# CITY OF ALBUQUERQUE

**Re: Guardian Storage  
Osuna and Juan Tabo (F21-D081)  
30-Day Temporary Certificate of Occupancy  
Transportation Development Final Inspection**  
Engineer's/Architect's Stamp dated 01-28-2020 (F21-D081)  
Certification dated 09-01-2021

SITE PLAN - DRB

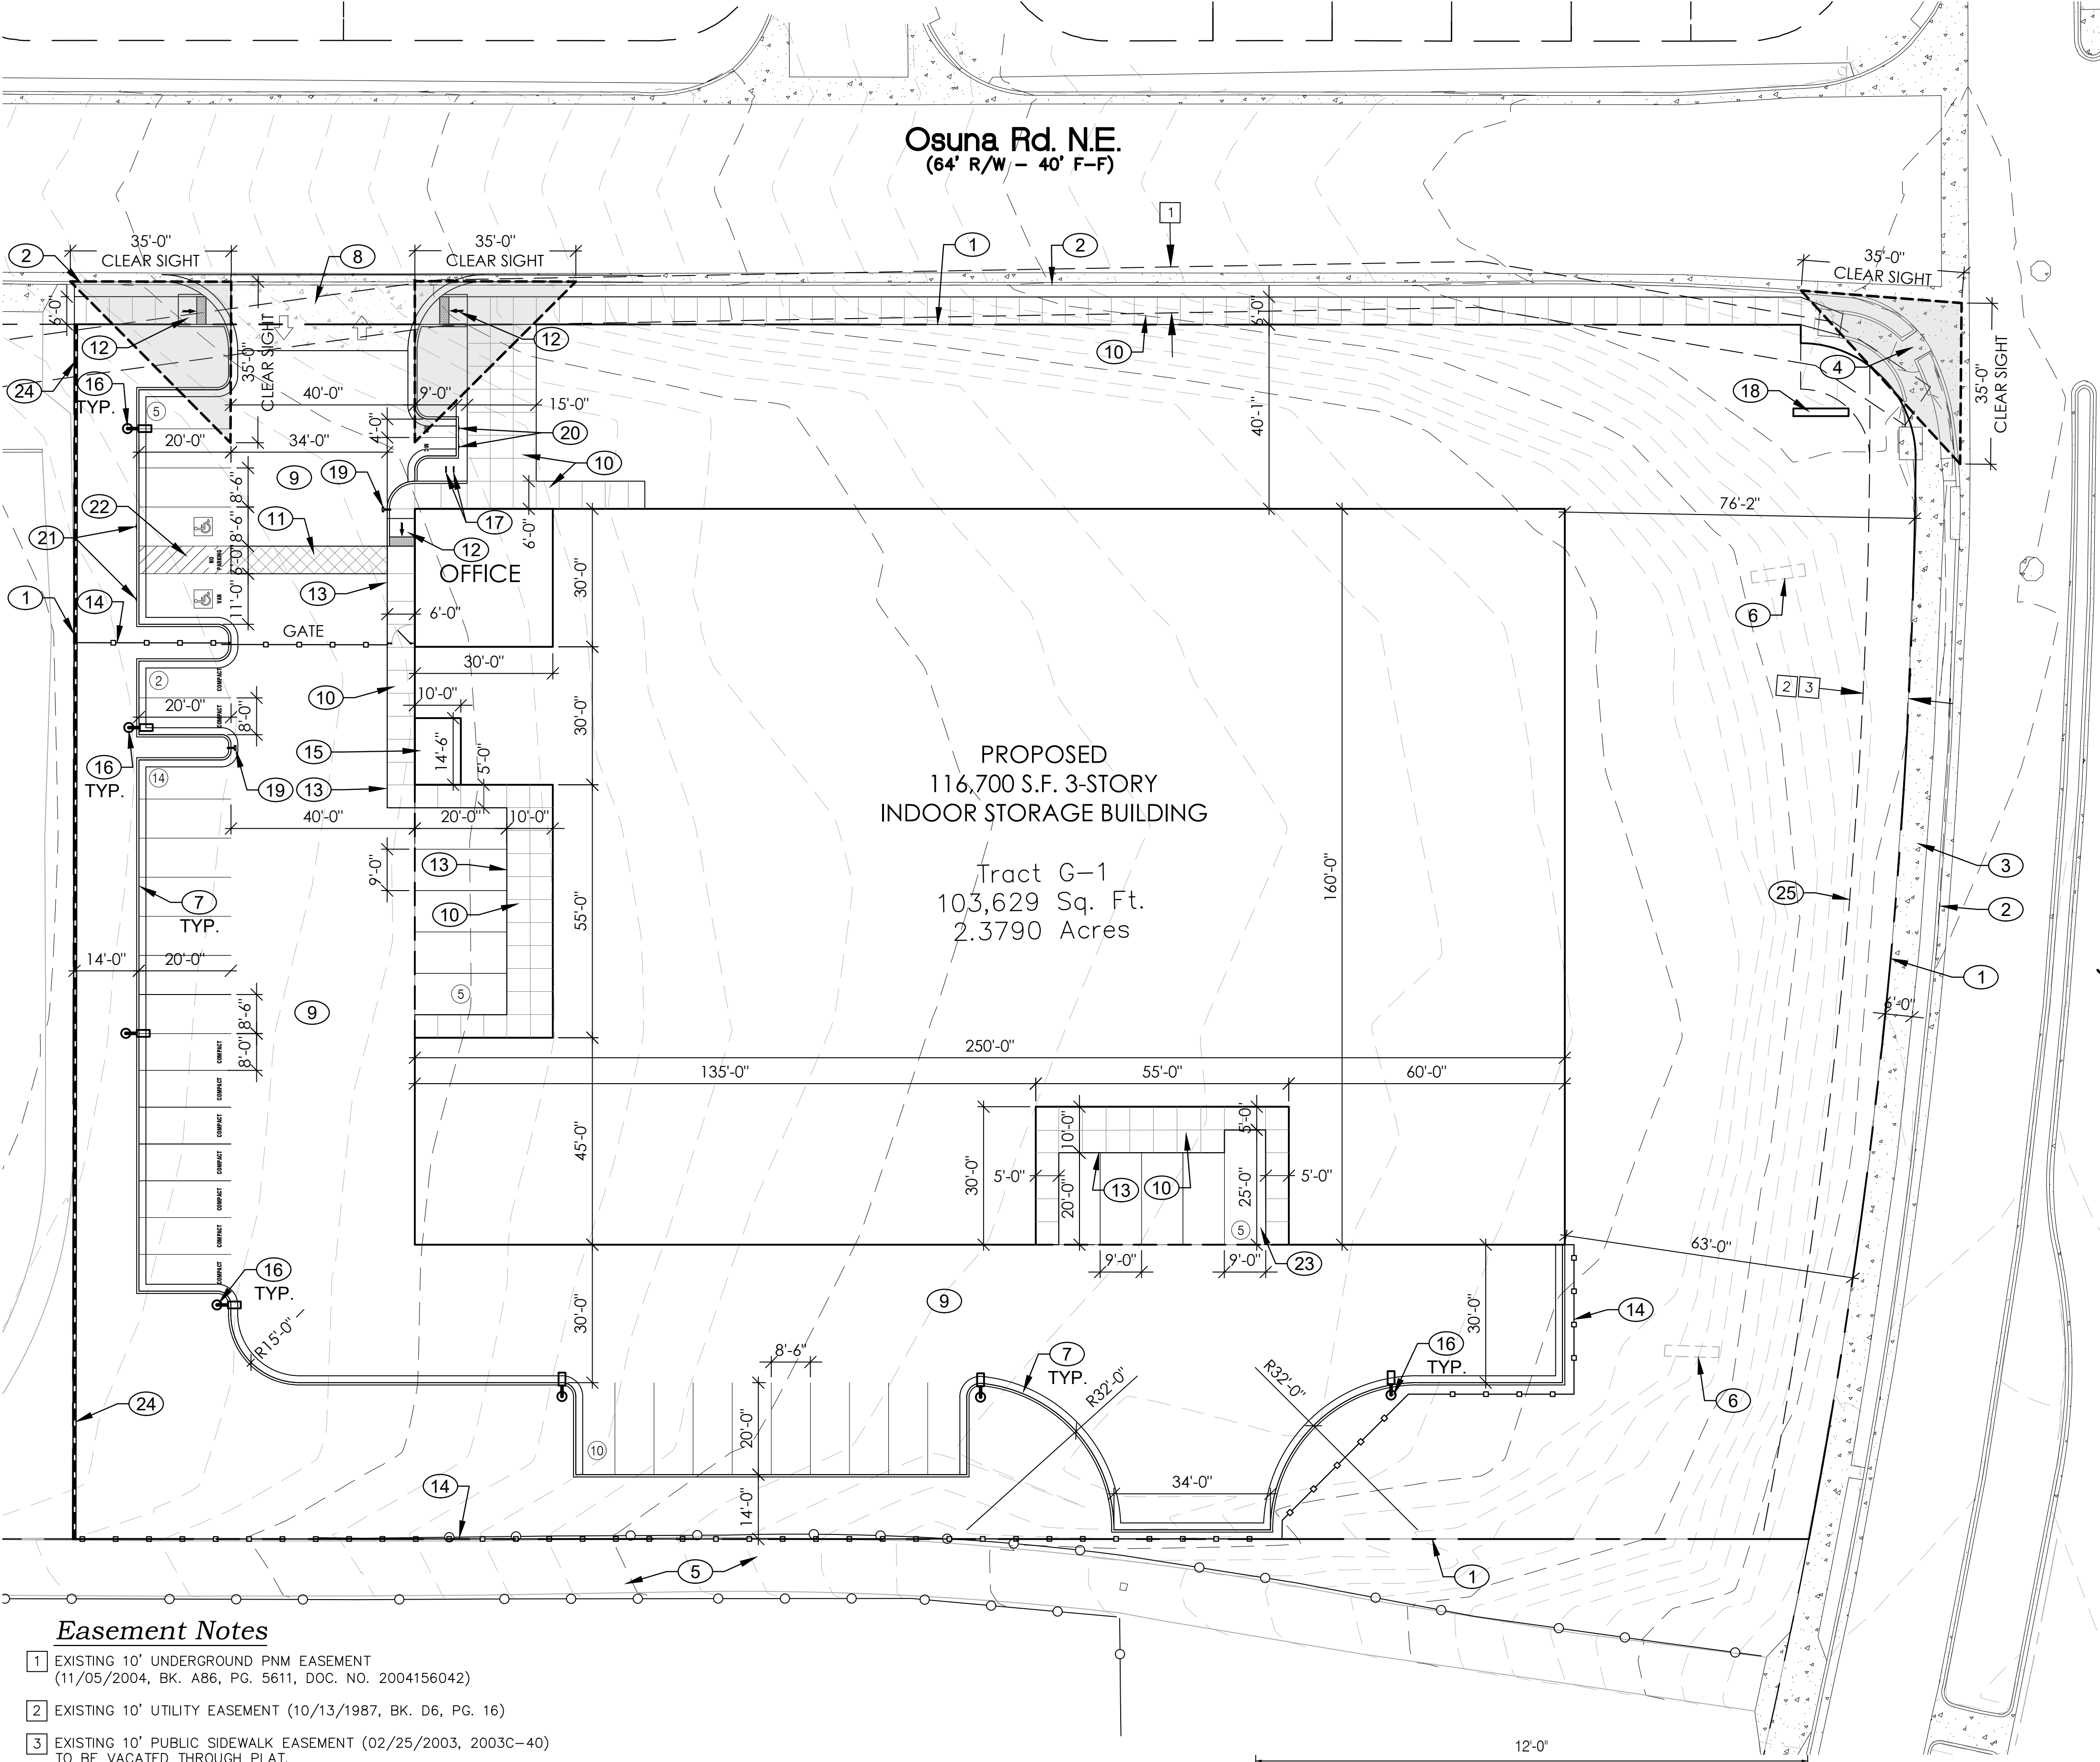
- Show handrail/steps on revised plan. (Nicely done and well thought out!) It is also understood that the overall updated plan is being submitted through the AA process.
- Include parking bumpers on all parking spaces against the building as per plan.
- Remove porta potty.
